Application Ref:	3/2026/0563			 Ribble Valley Borough Council www.ribblevalley.gov.uk
Date Inspected:	N/A	Site Notice:	N/A	
Officer:	LW			
DELEGATED ITEM FILE REPORT:				APPROVAL

Development Description:	Variation of condition 2 (plans) to change the external wall boundary on permission 3/2025/0227 for proposed single storey extension to rear.
Site Address/Location:	10 Hollies Road, Wilpshire, BB1 9NA.

PROPOSED EXTENSION

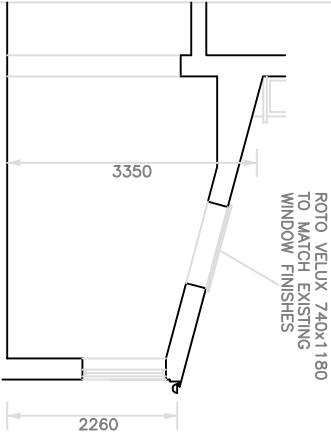
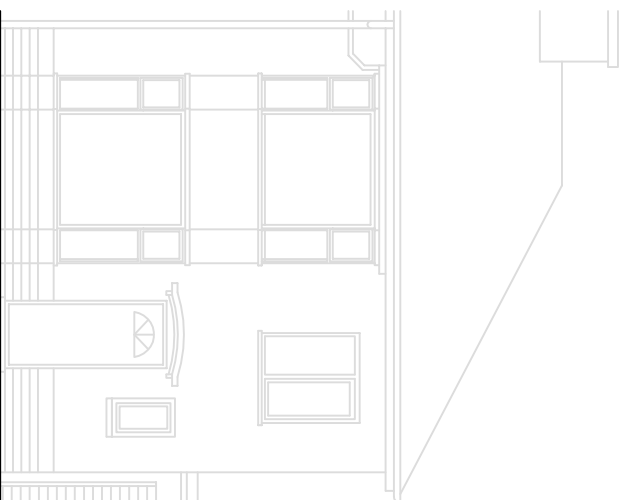
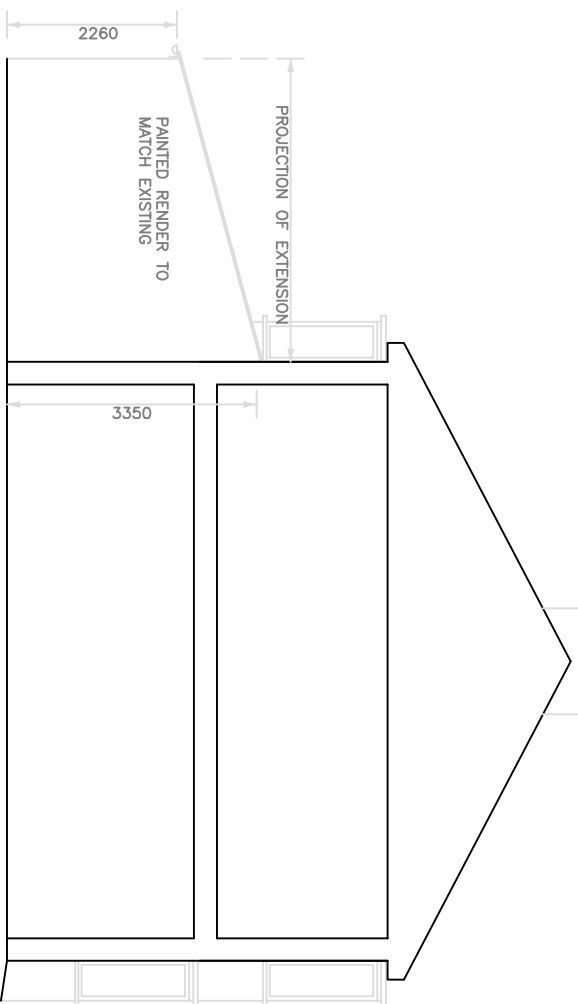
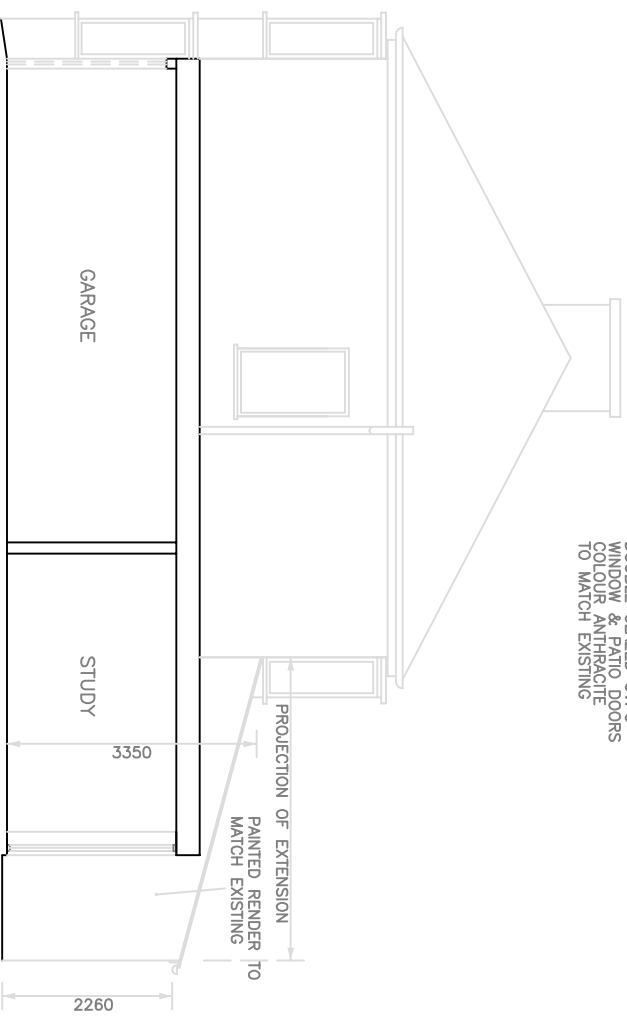
The proposed alteration to the proportions of the rear elevation window is similarly considered acceptable, as it would not introduce any additional overlooking, loss of privacy, or other adverse effects upon neighbouring residential amenity beyond those associated with the approved scheme.

The proposed amendments, comprising a 0.25m increase in the width of the extension and a modest increase in the size of the rear elevation window, are considered to have a negligible impact on the overall design, scale and appearance of the development. The amendments would not materially alter the character of the approved extension or its relationship with the host dwelling and the surrounding area. Accordingly, no concerns are raised in respect of design or visual amenity.

PROPOSED EXTENSION

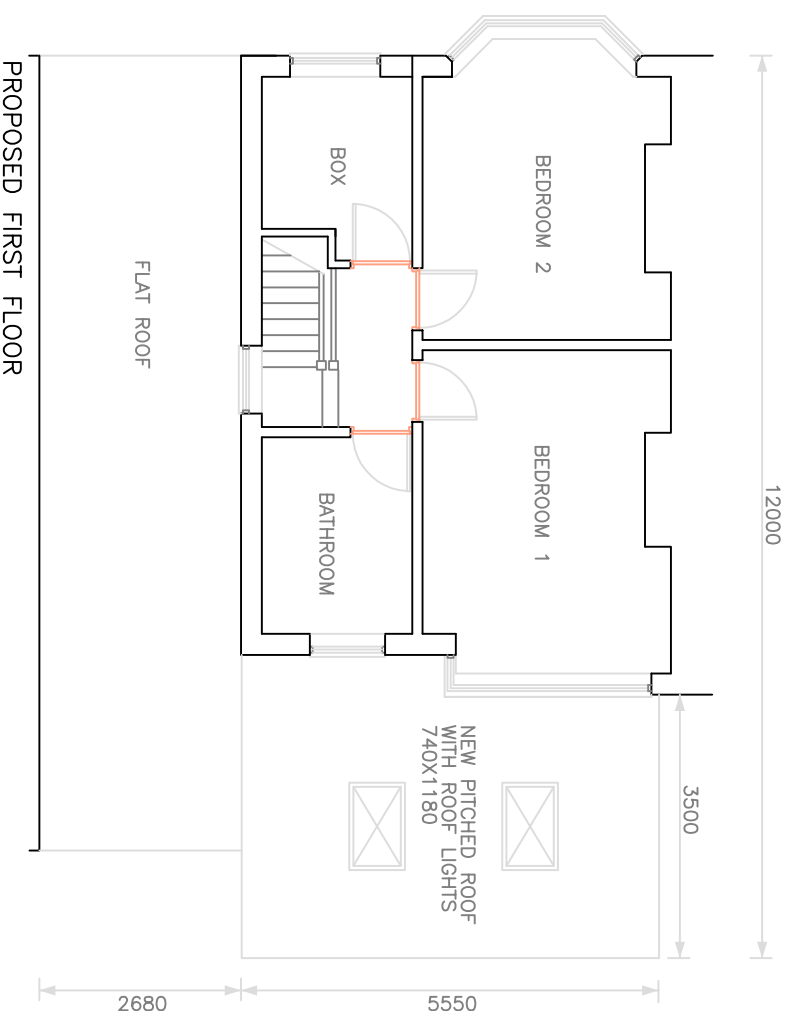
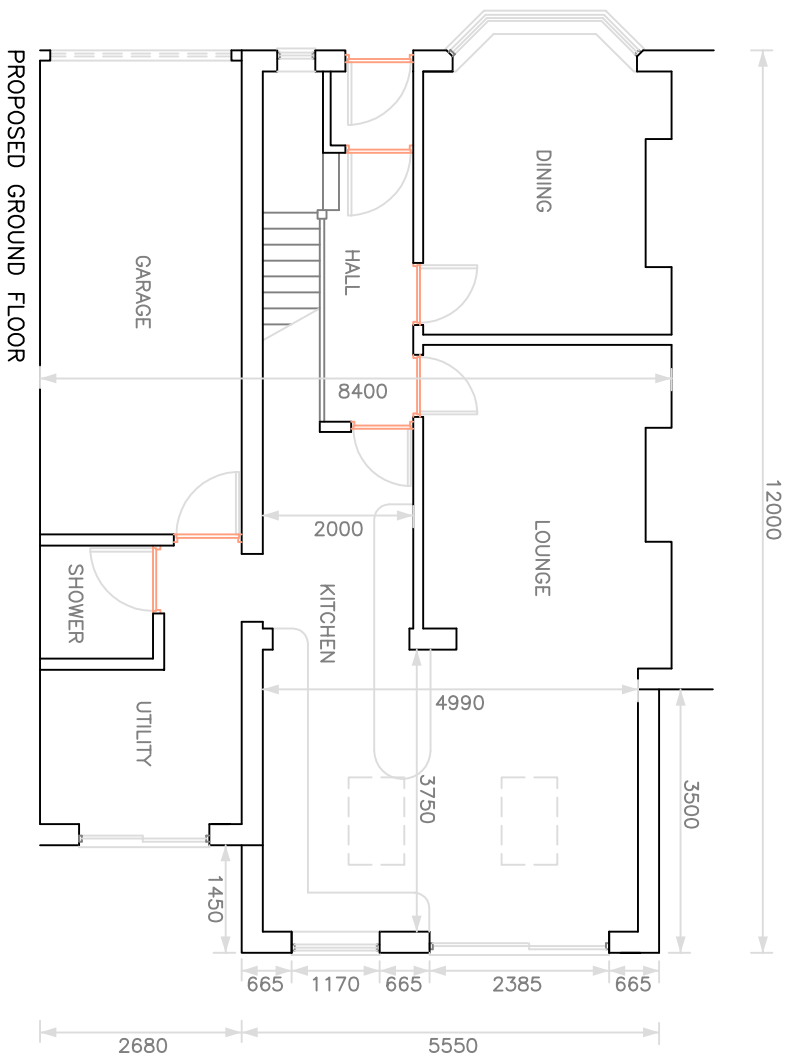
The application seeks permission to amend the approved scheme through a 0.25m increase in the width of the previously approved rear extension. As a result, the extension would be positioned approximately 0.25m from the shared boundary with No. 12 Hollies Road, rather than the 0.5m separation approved under application 3/2025/0227.

The supporting information submitted with the current application explains that, during construction, it became apparent that the approved wall position could not reasonably be achieved while maintaining the structural integrity and practical construction requirements of the extension. The applicant advises that an appropriate structural connection to the existing rear wall could not be secured whilst retaining the approved 0.5m separation from the boundary. Consequently, the extension has been constructed approximately 0.25m from the shared boundary, which is stated to represent the maximum achievable offset without compromising the structural stability of the development.

Whilst the amended scheme would position the extension closer to No. 12 Hollies Road than previously approved, the additional impact arising from a 0.25m reduction in the boundary separation is considered to be relatively limited. No increase in the height or rearward projection of the extension is proposed, and the overall scale and form of the development remain substantially as approved. Accordingly, whilst a marginal increase in overshadowing may result, it is not considered that the amendment would give rise to a materially greater impact upon the living conditions of neighbouring occupiers than that already accepted under planning permission 3/2025/0227.
